Appeal Decision

Appeal Ref: APP/R5510/W/21/3271124

Annex, 96 Bourne Avenue, Hayes, UB3 1QP

- The appeal is made under section 78 of the Town and Country Planning Act 1990 against a refusal to grant planning permission.
 - The appeal is made by Mr J Khasria against the decision of London Borough of Hillingdon.
 - The application Ref 76034/APP/2020/4095, dated 7 December 2020, was refused by notice dated 4 February 2021.
 - The development proposed is alteration to roof in order to convert the roofspace to habitable use to include a rear dormer and 1 x front rooflight and alterations to entrance.
-

Drawing Title:
Proposed Floor Plans

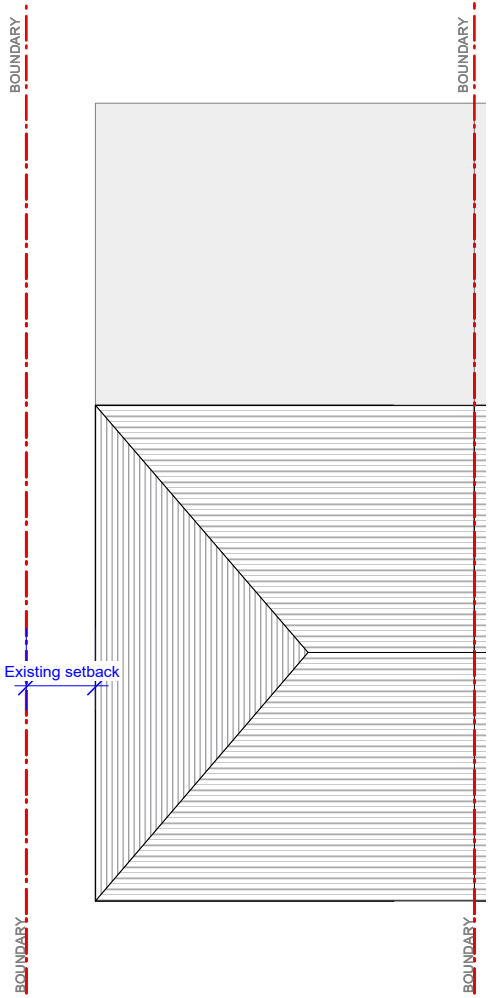
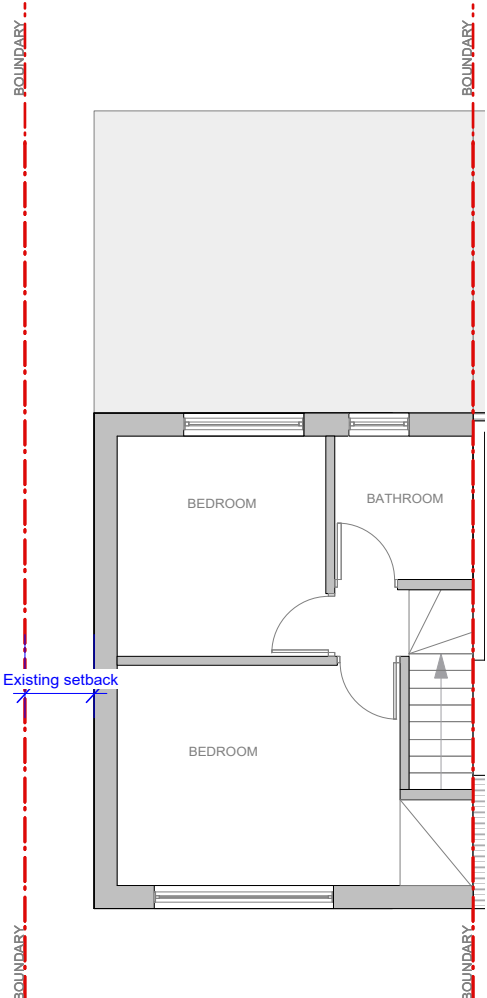
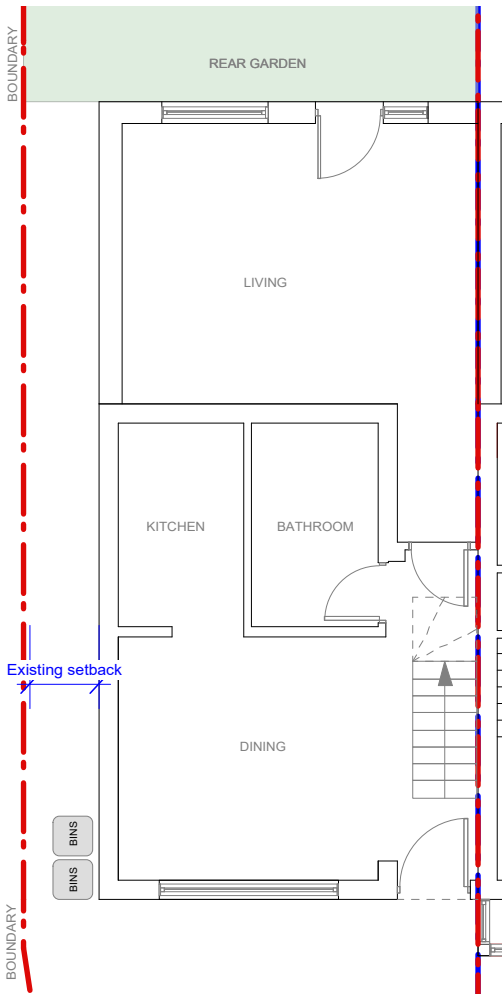
10. The extended property would fall below the internal floor area requirements of the space standards³ for a 2-person 1 bedroom 2 storey dwelling. Notwithstanding this, there is no indication before me as to whether the existing or proposed property is a 2-person dwelling. The proposed bedroom meets the minimum floor area for a single bedroom and the standards do not provide a size for a 1 person, 1 bedroom, 2 storey dwelling.

11. While the bedroom would appear to have restricted ceiling height in part, the above standards refer to the minimum floor to ceiling height for the gross internal area of the dwelling. The Council refer to the restricted height in the roofspace only. They have not provided dimensioned plans or stipulated the extent of any shortfall and have not indicated that the ceiling height for the gross internal area of the dwelling as a whole falls below the standards.

13. There would be an open and regular shaped living area at ground floor level. Overall, the property would be larger than at present, providing greater internal space than the existing studio flat does. I am satisfied that, on the individual circumstances of the case before me, any limitations in the size of the unit are not sufficient to warrant the dismissal of the appeal.

Drawing Title:
Proposed Elevations

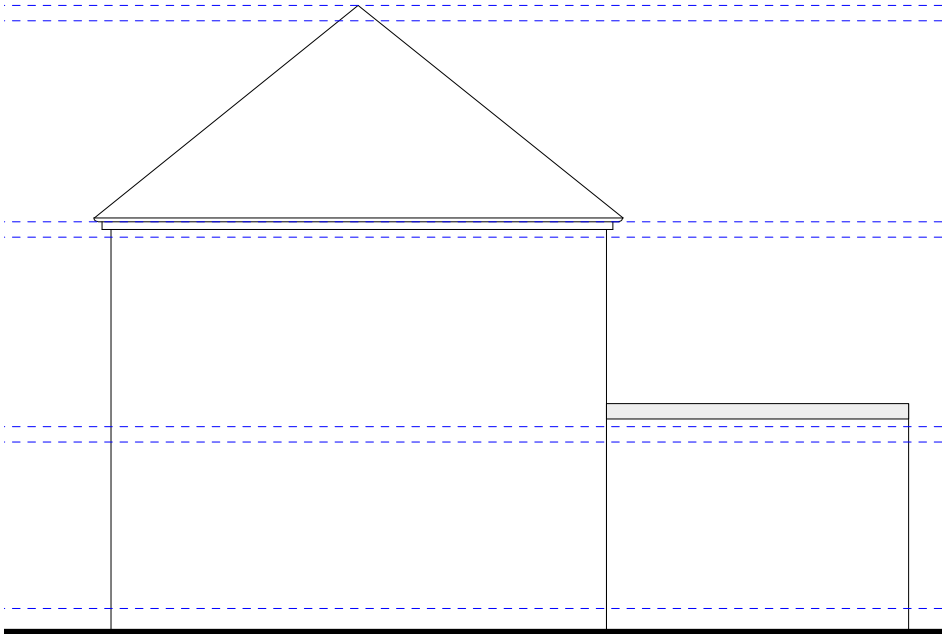
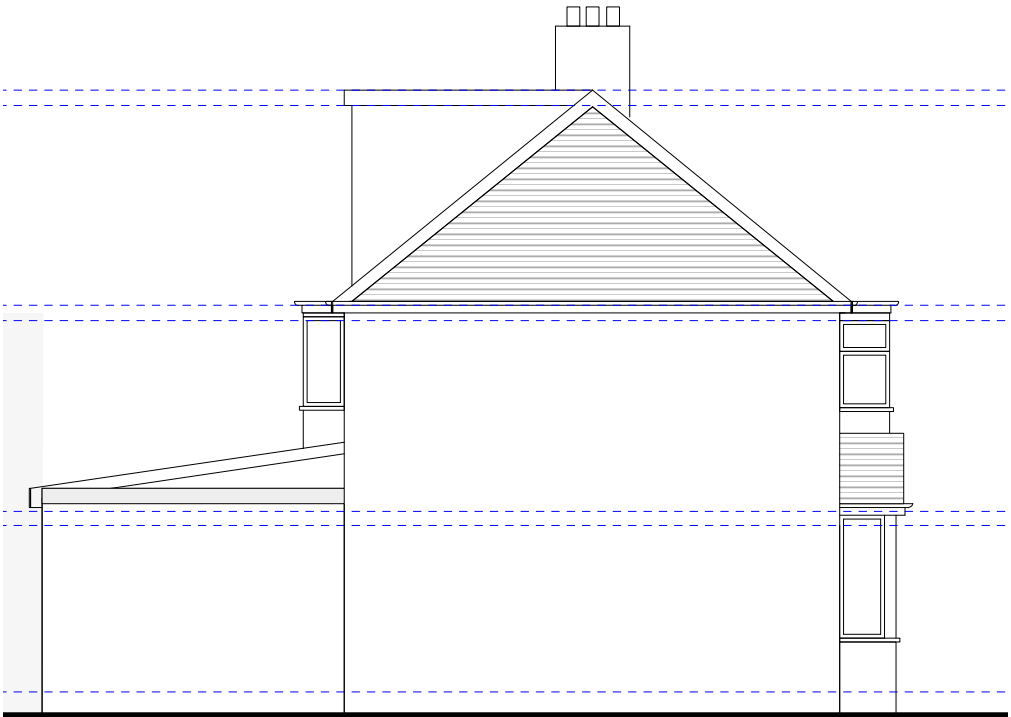
6. The existing single storey property is somewhat an anomaly in the street in terms of its appearance and scale. The proposed development would increase the height of the dwelling and alter the roof shape. However, the increase in size of the roof would not be significant. As such, it would not result in a top-heavy appearance and the building would still be lower than the nearby dwellings. In addition, with a hip to one side and gable attaching to the adjacent dwelling to the other, the resultant roof would be more in keeping with the general appearance of the main roofs of dwellings in the street.

7. The proposed dormer would occupy a large part of the rear roof space and the property is in a highly visible corner location. Nevertheless, the dormer would be set in from either side of the roof and set down from the ridge line. This and its relatively small size would result in it not dominating the roofscape. Furthermore, it would be seen with, be smaller and lower than, the flat roof dormer at 96 Bourne Avenue that is at a greater height and already prominent from Clevedon Gardens.

8. The appeal property would be closer to Clevedon Gardens than 108 Bourne Avenue (No 108) is at present. However, the appeal scheme would not bring the building line closer to the side boundary. The increase in height would be modest and there would remain a large degree of separation to No 108. The openness of the streetscene would be retained and I saw properties with similar or less separation to their side boundaries at corner locations nearby.
